**Case Officer:** Lewis Knox

**Applicant:** Mr J Bonas

**Proposal:** Single storey side extension, canopy porch and alterations to enlarge Kitchen & Dining Room

004A elevations

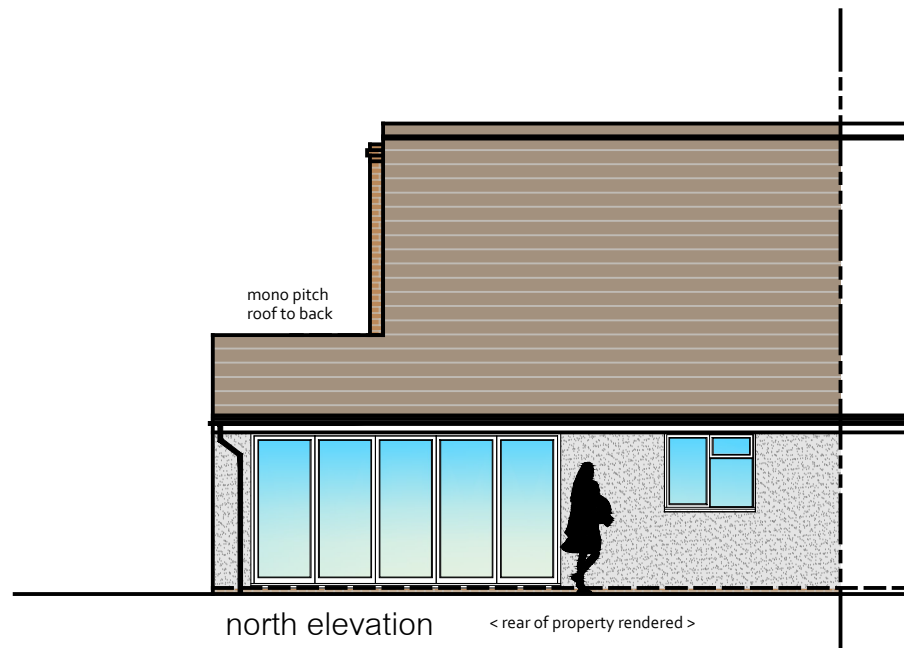
- 8.8. The extension would feature small mono-pitched roofs to the front and rear which would match the roof slope of the main dwelling and would therefore respect the established character of the site. The flat roof between would be largely hidden from view.

- 8.10. The front elevation of the application dwelling is to be rendered and so the front of the proposed extension would match this. It would have been preferable to keep the existing brick frontage in order to match with the rest of Sefton Place, however given it is not a sensitive area it is considered to be acceptable in this instance.

- 8.16. There are no additional windows proposed on the eastern (side) elevation of the extension which would face towards the neighbouring dwelling and would therefore not impact on the levels of privacy in the locality.

- 8.17. There would be one door which faces south across the highway along Sefton Place, and all other openings would face towards the rear of the garden at the application site and would not face any other neighbouring dwelling. It is therefore considered that the development would not impact on the levels of privacy.

003 roof plan

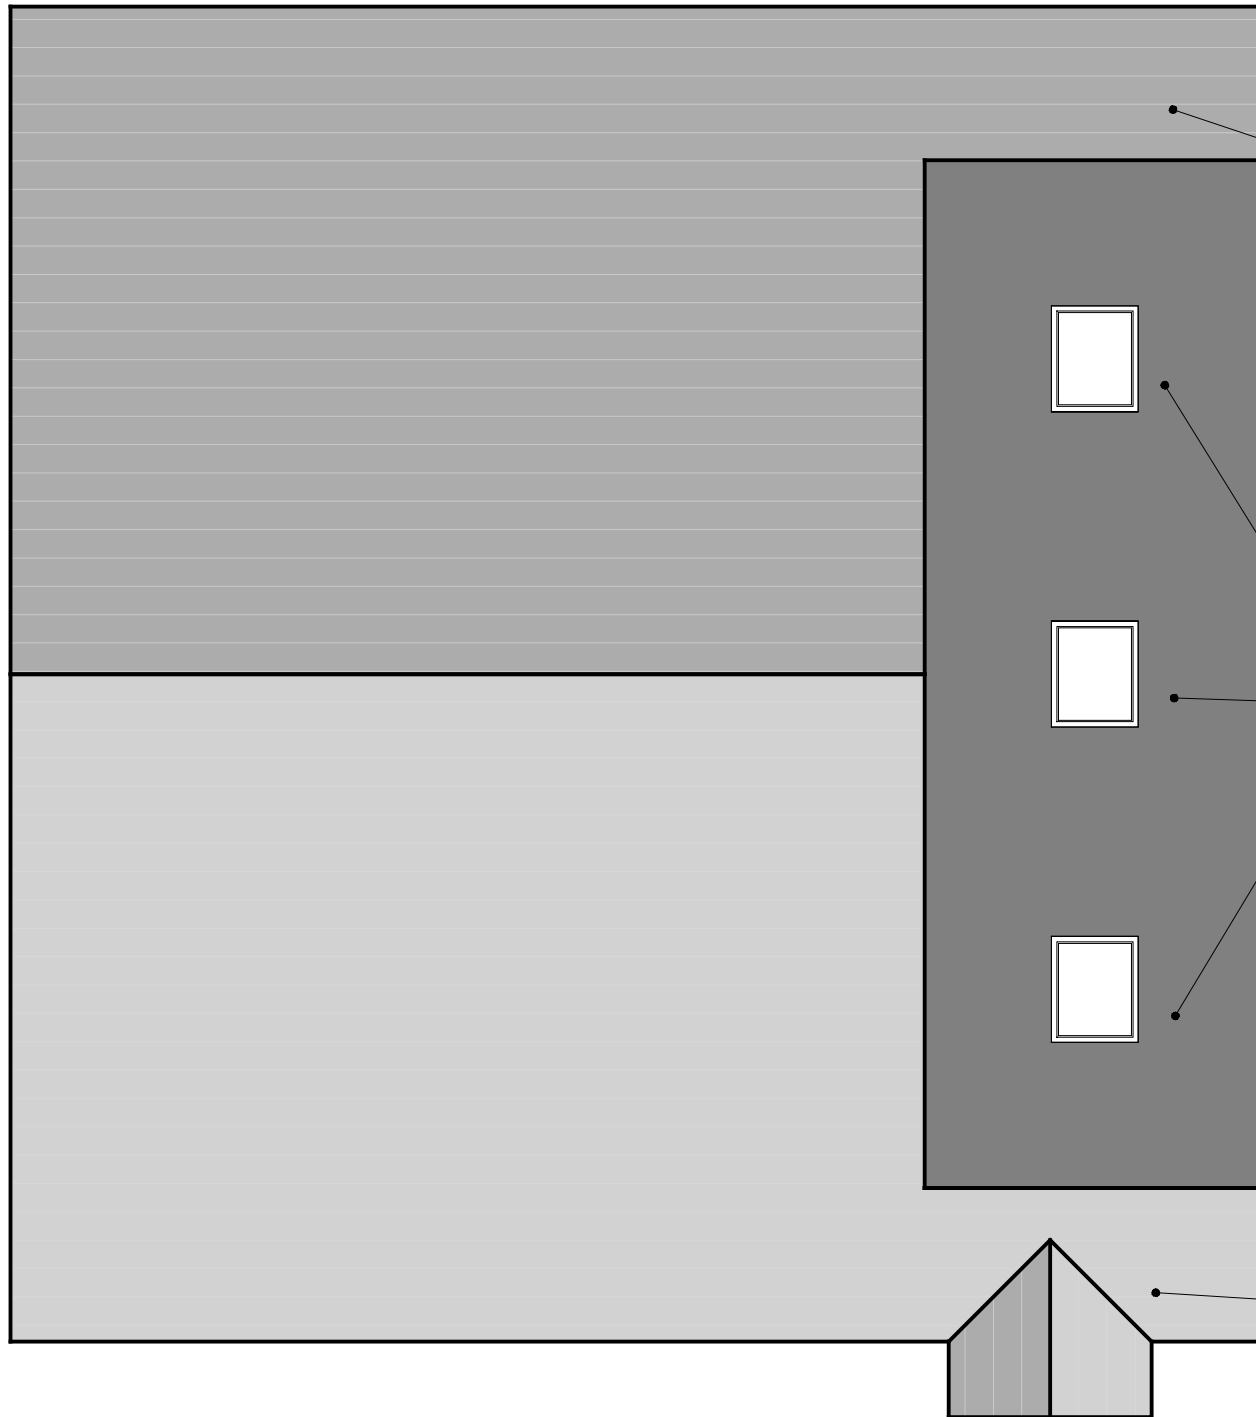
- 8.11. The roof tiles would be interlocking to match the existing and would be acceptable.
- 8.12. The proposed canopy porch would be minor in scale and would not have cause harm to the character and appearance of the streetscene.
